TRAFFIC IMPACT STUDY

El Paso County, Colorado

DATE:
July 10, 2023

PCD File No. CS224

EXISTING DRAINAGE MAP

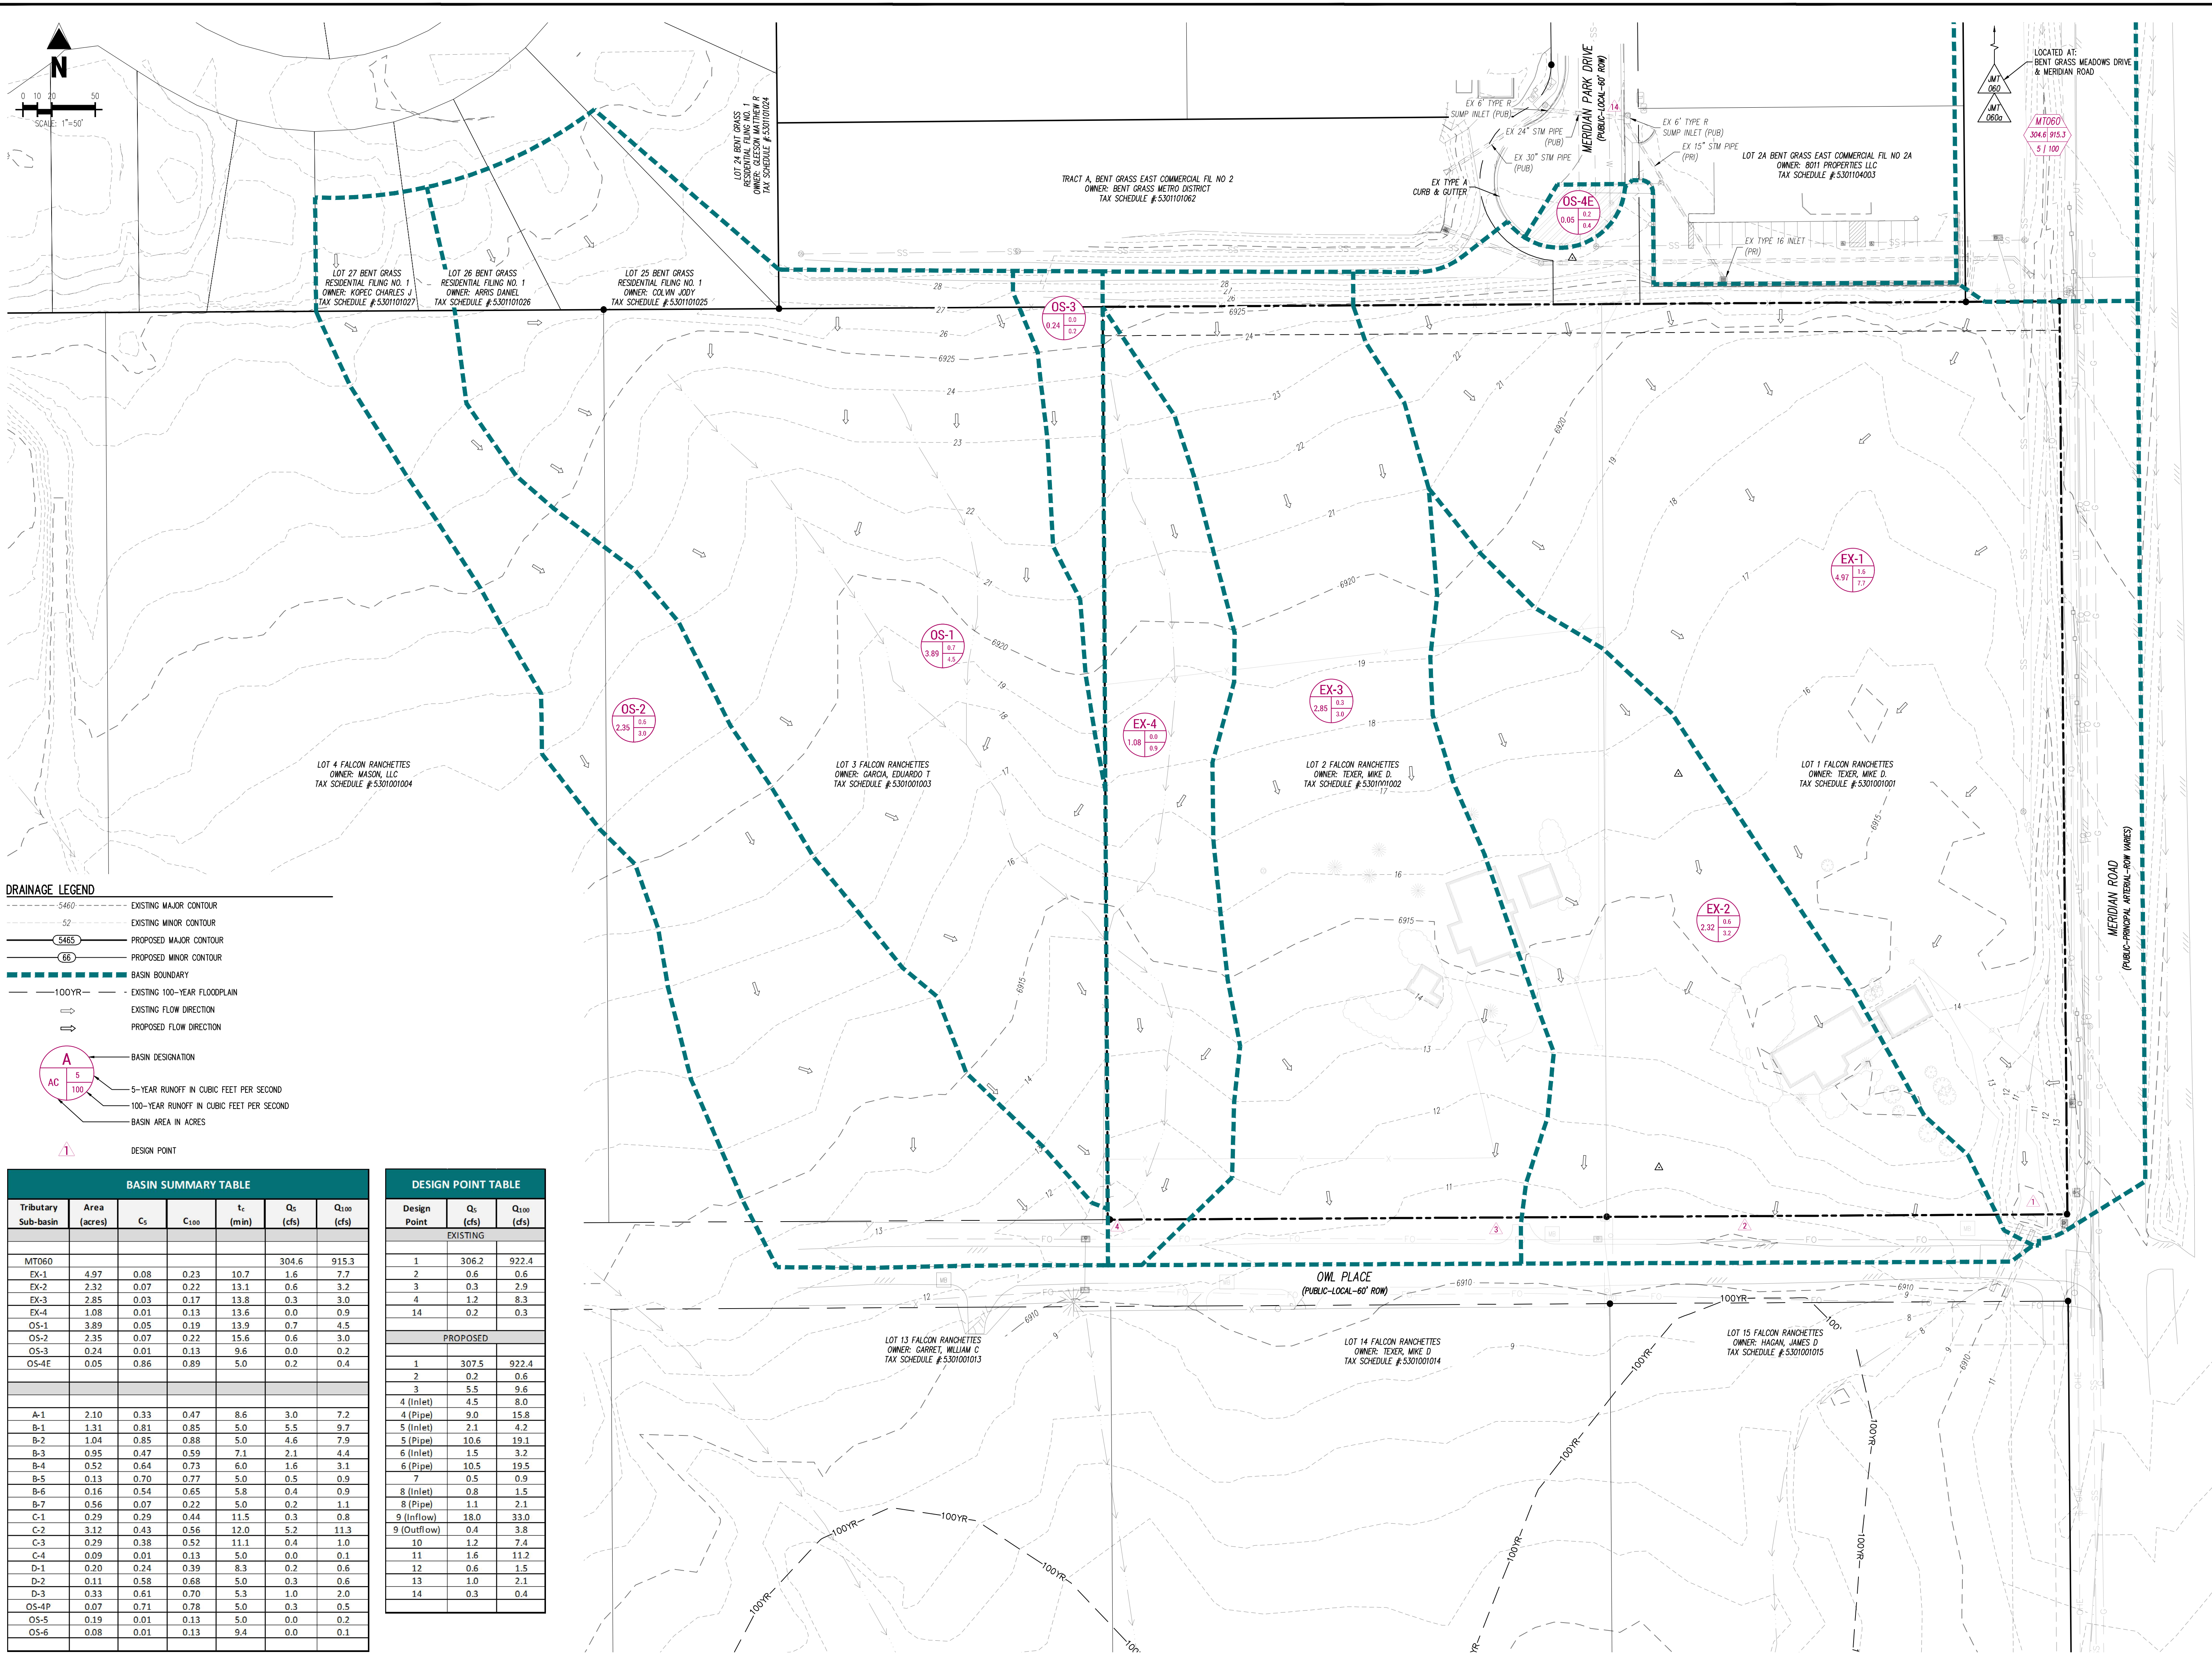
The Traffic memo shall analyze and state whether any aux. turn lanes or TWLT striping is recommended/proposed along Meridian park drive for turn movements into the two proposed lots. Provide recommendations for the proposed gate locations to ensure sufficient queuing without blocking Meridian Park Drive.
